09 May 2013

**Subject: State Significant Development Application for a staged mixed use development comprising residential, commercial, retail, community and open space uses at The Haymarket (Concept Proposal) (SSD5878)**

Parameter plan shadow DD Plot

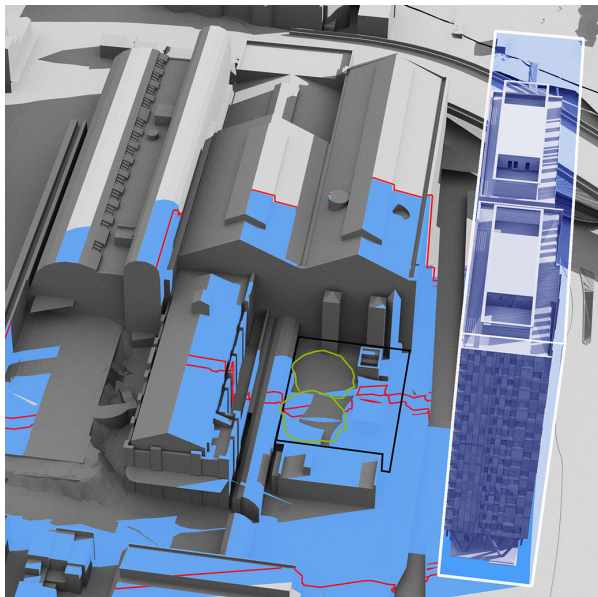
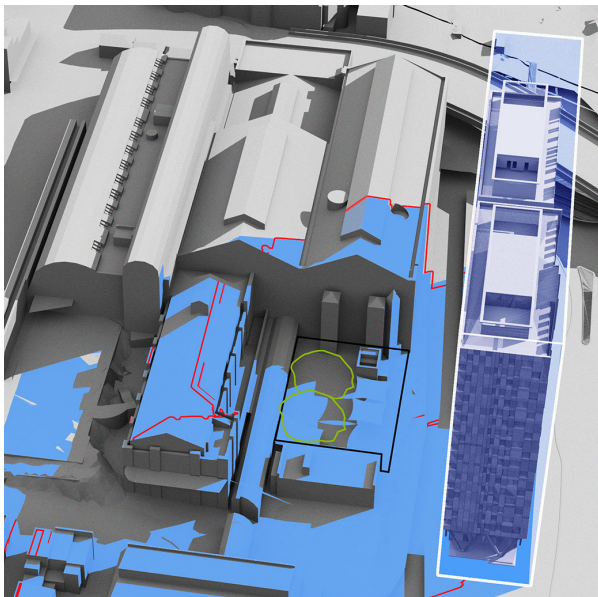
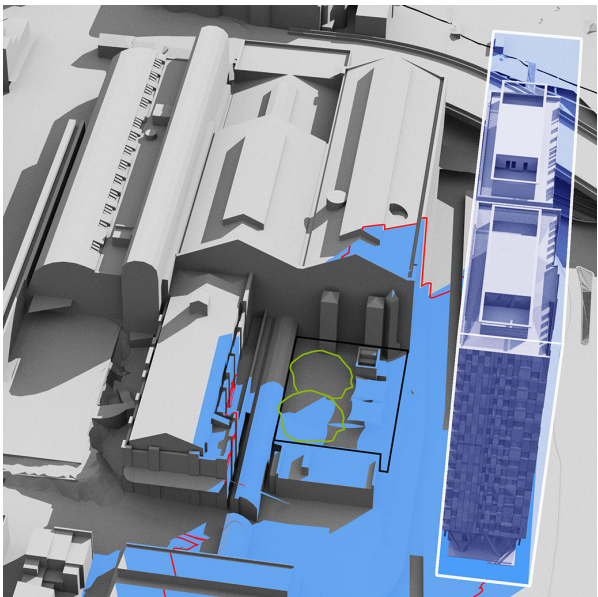
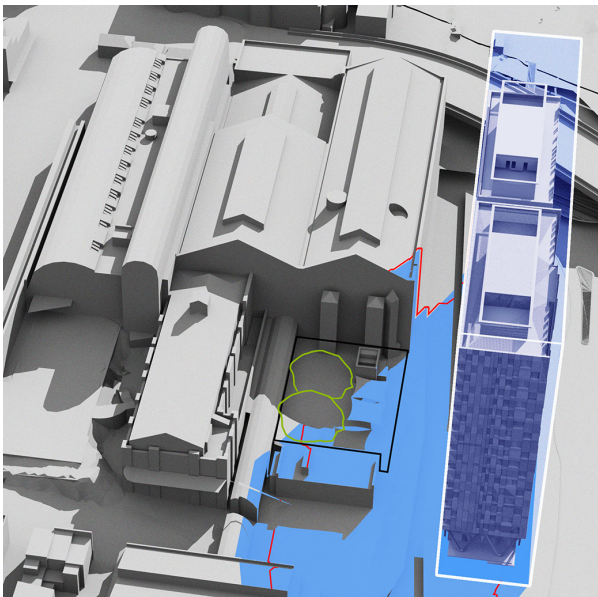
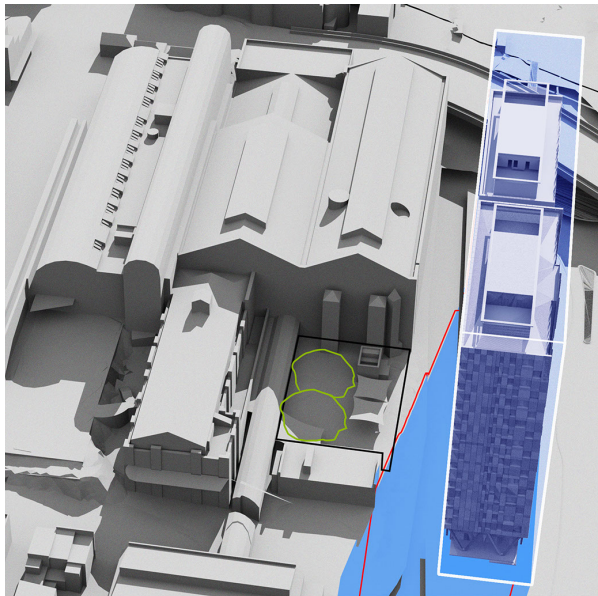
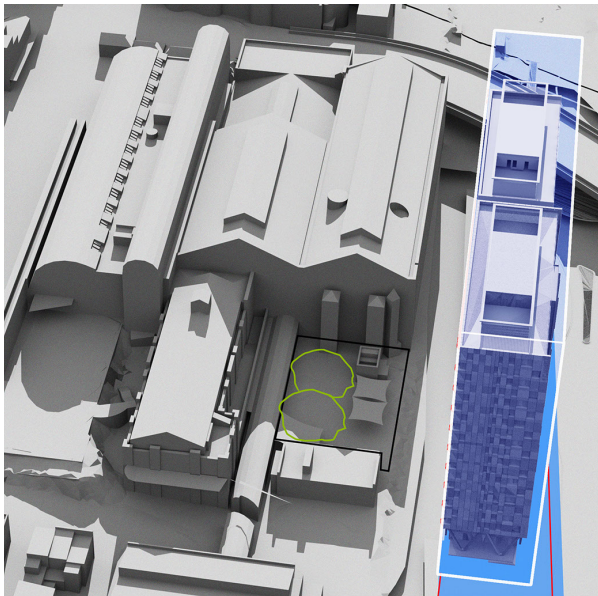
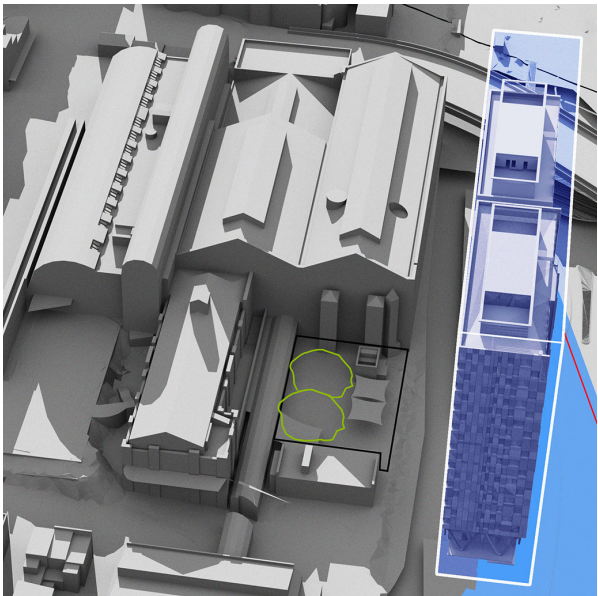
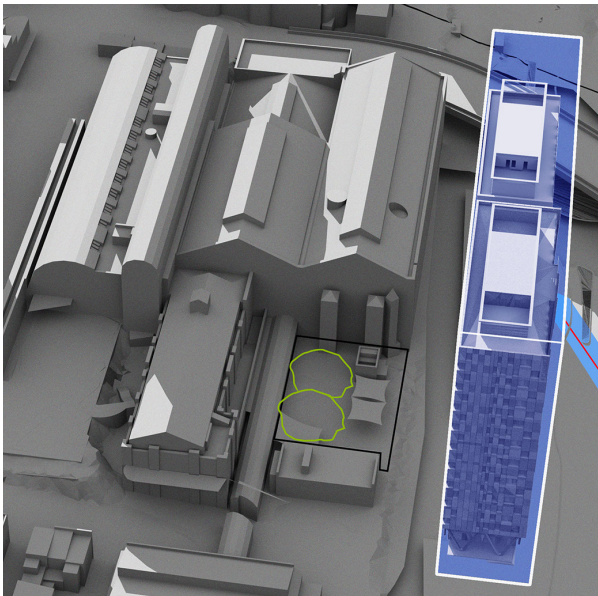
The EIS does not contain sufficient information to assess the number of individual dwellings in neighbouring tall buildings which will be overshadowed at any time, and in particular at the winter solstice. No information is given re vertical (elevation) shadowing. It will be too late by the DA stage to belatedly realise that DCP overshadowing guidelines are far from met for a substantial number of individual dwellings.

In fact, contrary to the requirements of the DCP, the overshadowing diagrams in the EIS are in plan only (Appendix J, pages 74 - 80). The EIS does not include any overshadowing diagrams in elevation. Therefore it is impossible to assess the extent of overshadowing of individual neighbouring dwellings within tall buildings, i.e. The Peak and The Quay. For example, it is very likely that dwellings in the lower floors of North and West facades of these buildings will receive less than 2 hours direct sunlight to habitable rooms between 9am and 3pm on 21 June. This may also be the case for medium-level floors. It is impossible to tell from the incomplete information contained in the EIS. The EIS does not contain sufficient information to assess the

number of individual dwellings in neighbouring tall buildings which will be overshadowed at any time, and in particular at the winter solstice. In the absence of diagrams in elevation, the EIS simply makes the global statement that "The Peak Apartments residential tower (north and west facades only) would be partially overshadowed by the Concept Proposal in the late afternoon at the winter solstice." No information is given to allow assessment of the number of individual dwellings which will no longer meet the DCP guidelines. The EIS says nothing about shadowing of The Quay apartments. That is not good enough. The EIS should have contained overshadowing diagrams in elevation and a detailed analysis of the impact on dwellings in large facades. It will be too late by the DA stage to belatedly realise that DCP overshadowing guidelines are far from met for a substantial number of individual dwellings.
